**From:** [REDACTED]  
**Sent:** 07 April 2022 15:38  
**To:** Planning <[Planning@arun.gov.uk](mailto:Planning@arun.gov.uk)>  
**Subject:** Planning Application BN/16/22/PL

## For the attention of Case Officer Amber Willard

### **YET MORE MISREPRESENTATIONS – STREET SCENE and DESIGN**

DRWG. No 1474/14
SCALE 1:200 AT A3
© FEB '25th 2022

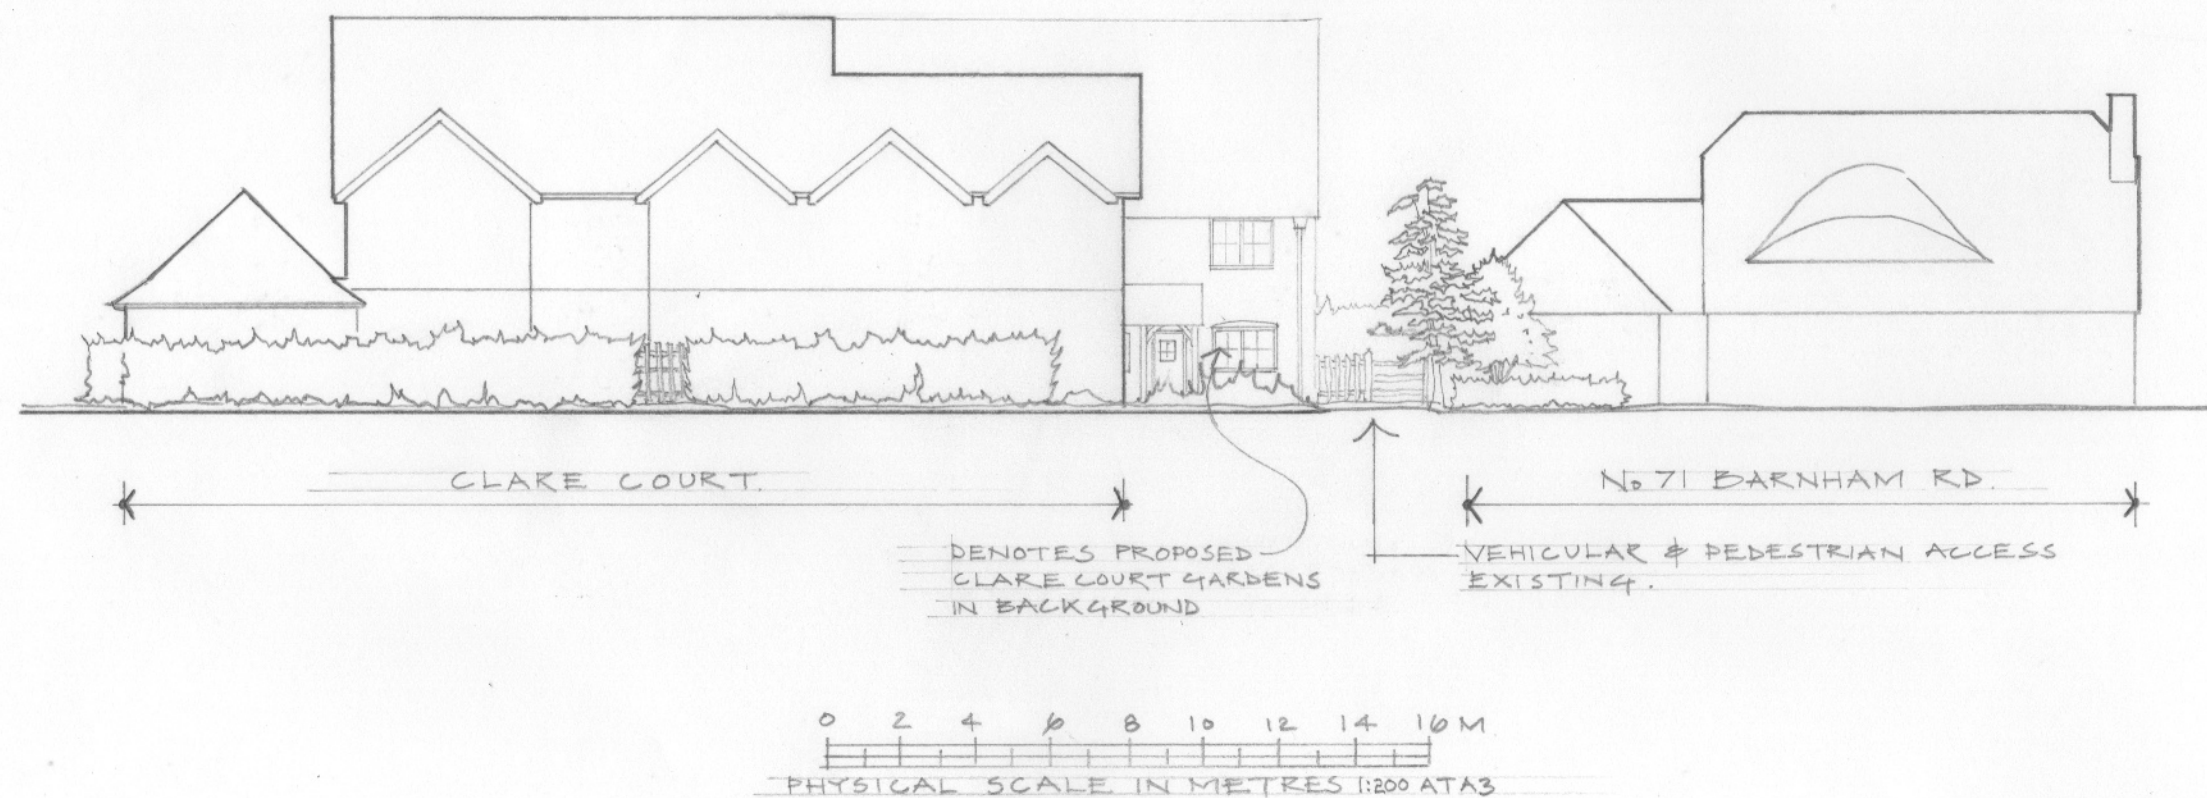
The proposed Street Scene drawing (1474/4) shows that a large portion of House No 1 and much of the roof of the entire first pair of houses, will be visible when viewed from directly opposite the entrance road. But this is far from being the whole story; to present the view from one convenient fixed spot belies the truth of the matter. The view from “the wider area”, referred to in the Pre-Application Advice, will include the entire row of houses – and this is what anyone driving or walking along Barnham Road in a southerly direction will see, namely, an EYESORE blighting our Area of Special Character.
